Historic England

Application by Ørsted Hornsea Project Four Limited for an Order Granting Development Consent for the Hornsea Project Four Offshore Wind Farm

The Examining Authority's written questions and requests for information (ExQ1) Issued on 28 February 2022

Planning Inspectorate Ref: EN010098

Figure: 1
Viewpoint 1: PRow South of Burn Park Farm

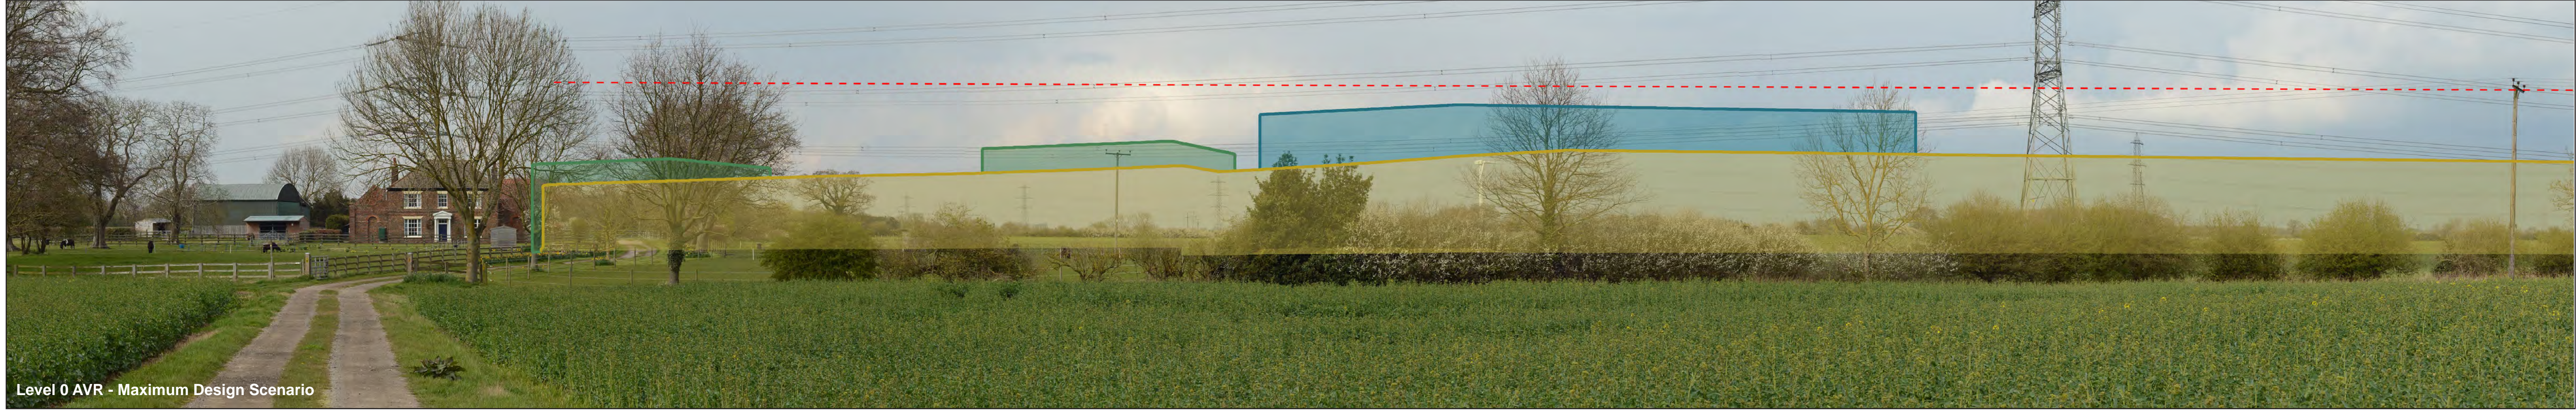
HBMCE has reviewed the list of viewpoints identified in ‘Vol 6, Annex 4.1: Landscape and Visual Resources: Wireframes and Photomontages’, and we consider that the selection of viewpoints presented by the Applicant is limited.

We note that the Onshore substation (OnSS) with Energy Balancing Infrastructure (EBI) and associated lightning protection, located to the north of Cottingham, East Riding of Yorkshire, is a large structural intervention in the landscape. The heights of the intervention range from 15 meters (EBI) to 25 meters (OnSS) and 30 meters (lightning protection).

However, as stated in our 'PINS Registration and Relevant Representation Form', we are concerned that the presentation of the assessment of the impact of the structures is limited to views from existing access points and PROW, whilst opportunities to minimise the harm generated are described as 'aspirations'.

It is established practice in the assessment of impacts on setting, that views are not limited to public access and PROW locations. Additional wireframes and photomontages are to be presented by the applicant illustrating a 'dynamic' or 'kinetic' progression through the landscape, illustrating the manner in which the relationship of views to and of the proposed structures and designated heritage assets unfold, specifically in the locations of Risby Park (NHLE 1018600; NHLE 1001419), Cottingham (NHLE 1347016) and Woodmansey (NHLE 10007731)

Opportunities to minimise 'harm' generated by the proposed structures are to include considered and definite schemes for increased planting and screening and the use of recessive colour schemes for the buildings.

HBMCE recommends that there should be a specific requirement in the DCO requiring submission of detail and sign off from HBMCE to ensure that:

- A) the 'dynamic' photomontages are undertaken and assessed; and
- B) the planting/screening proposals and the colour palette for the proposed buildings are contained within a Construction Environmental Management Plan.
